From: David Margolis-Pineo
To: Jean Fraser
Date: 1/24/2014 7:51 AM
Subject: Re: Fwd: Capisic Pond Improvements Project

Jean – I have reviewed the proposed plans and request that the following information be provided for the project.

**G-001**

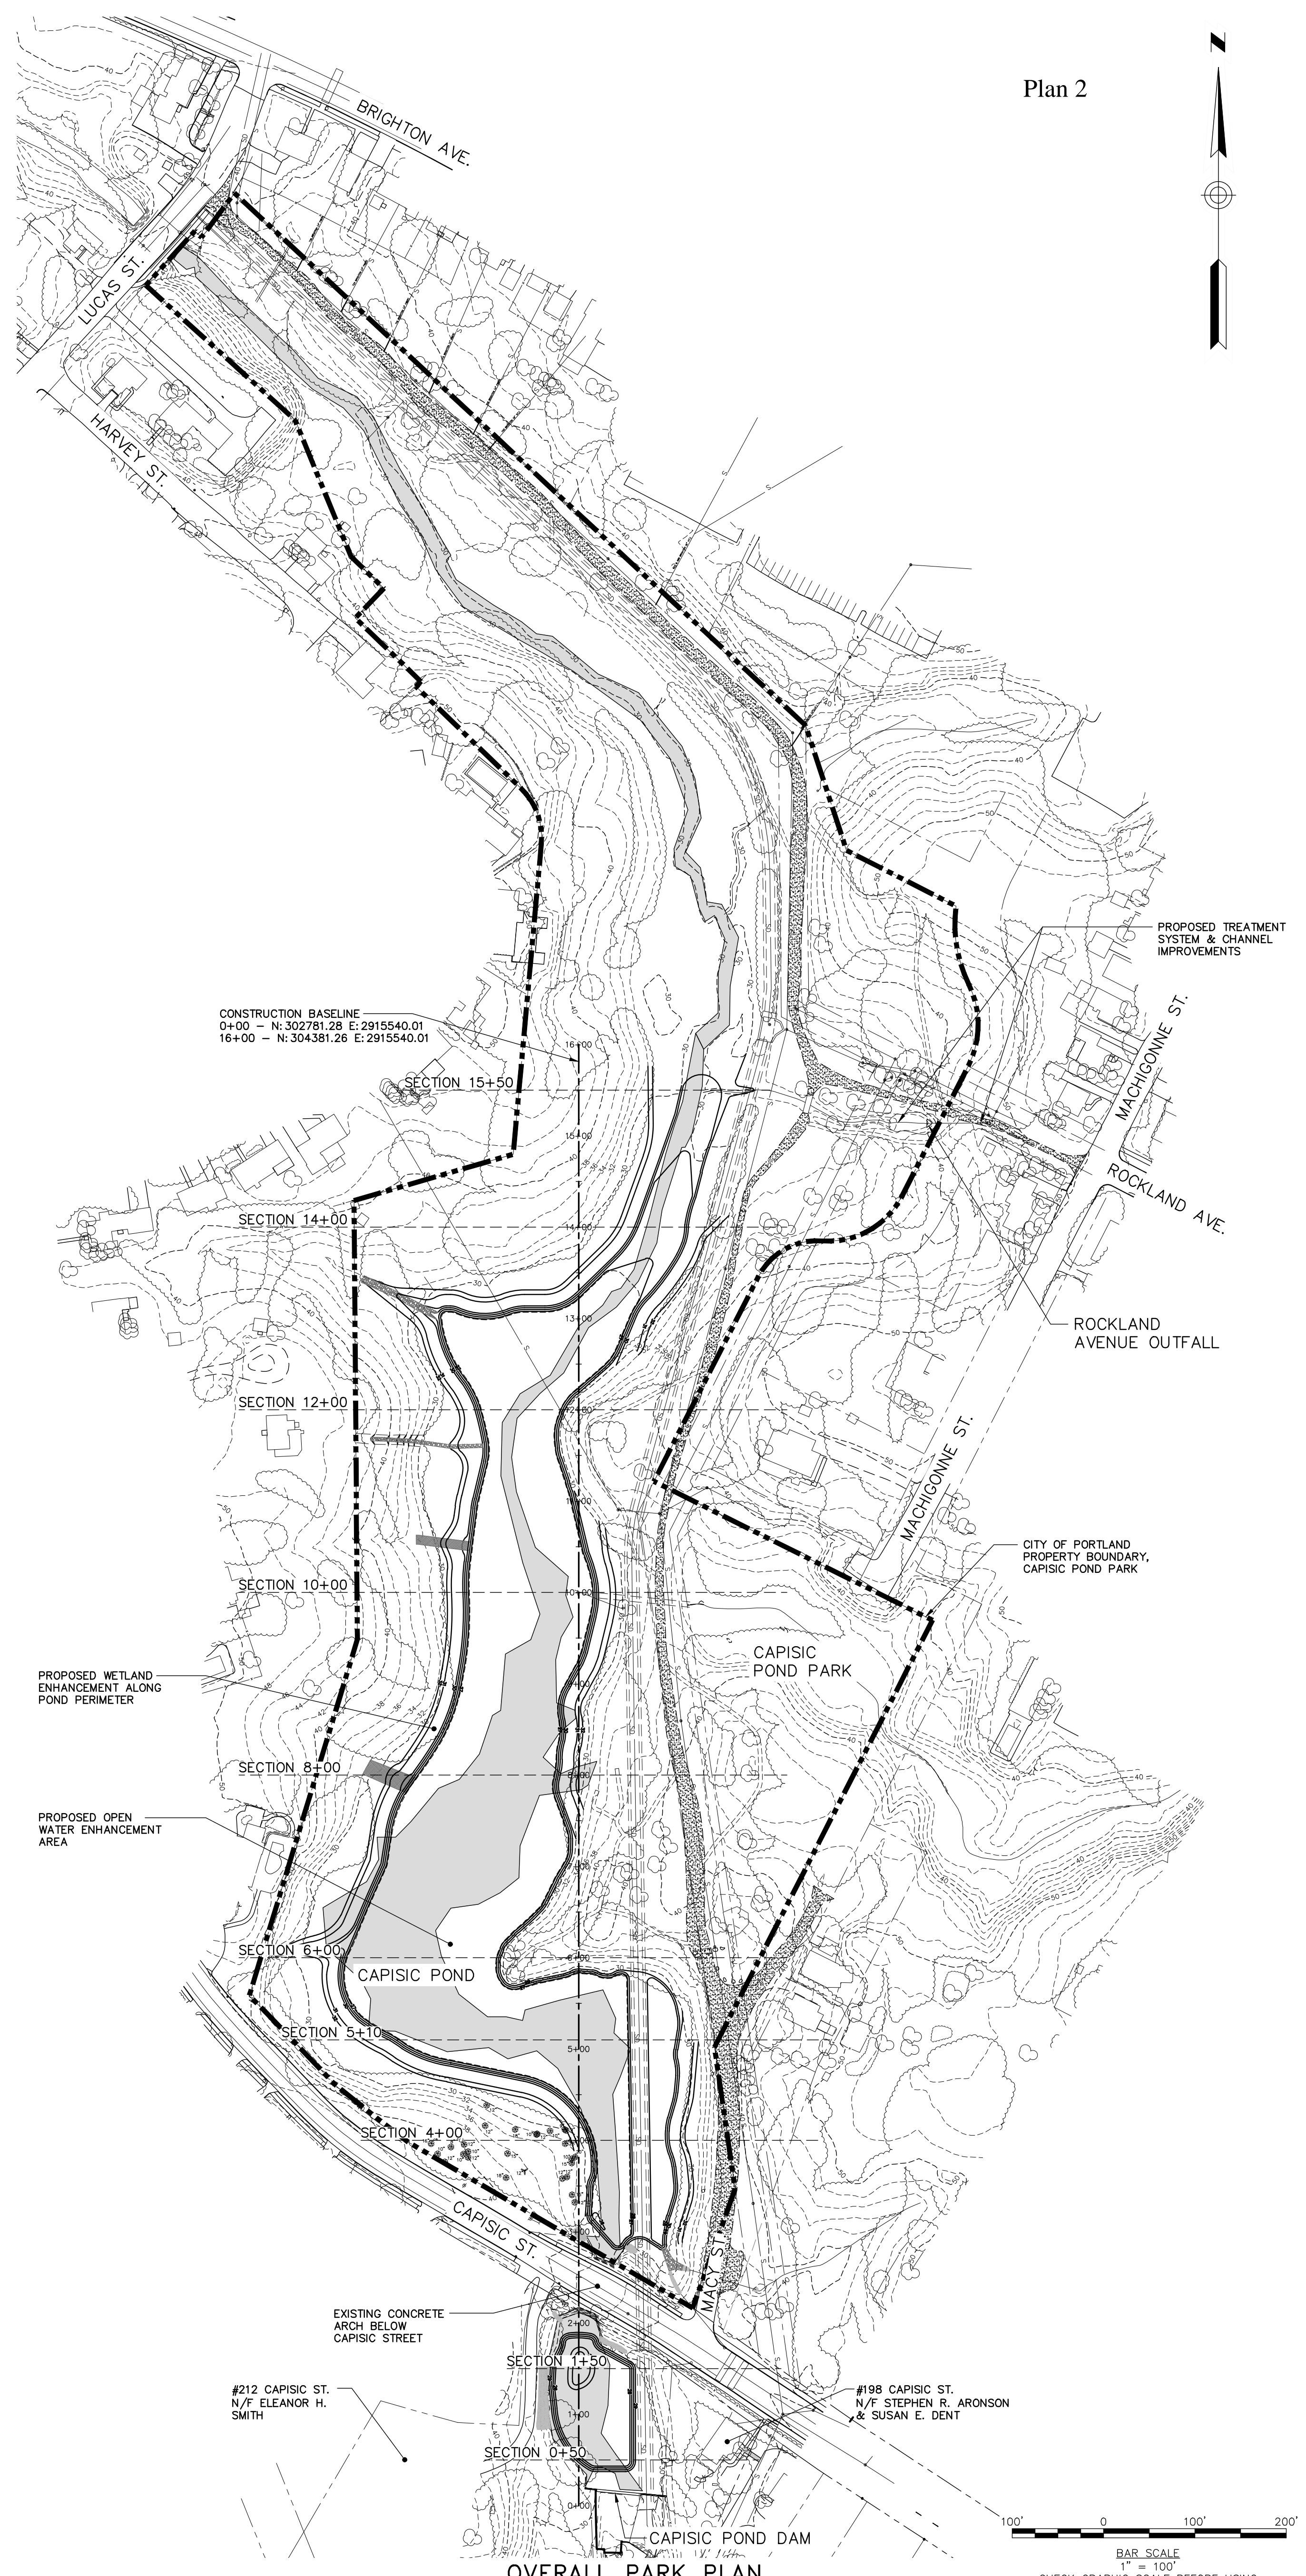
Please add a note to the plans stating that "The Contractor shall be responsible for any sweeping due to materials inadvertently falling on the roadway between the dredge and disposal site."

- The applicant shall provide an estimate of both daily and peak hour truck volumes entering and exiting the site.
- Sight distance measurements shall be provided for proposed temporary driveways with discussion on meeting City standards.
- A proposed truck routing plan shall be documented. It is my understanding that it is likely that trucks will be destined to the City of Westbrook via Brighton Avenue. Accordingly, it seems reasonable that the routing consist of travel along Capisic Street to Brighton Avenue. I would suggest that truck activity avoid peak drop-off and pick-up times at Breakwater School. Also, provisions to ensure that vehicles are cleaned prior to entering the public street system should be included.
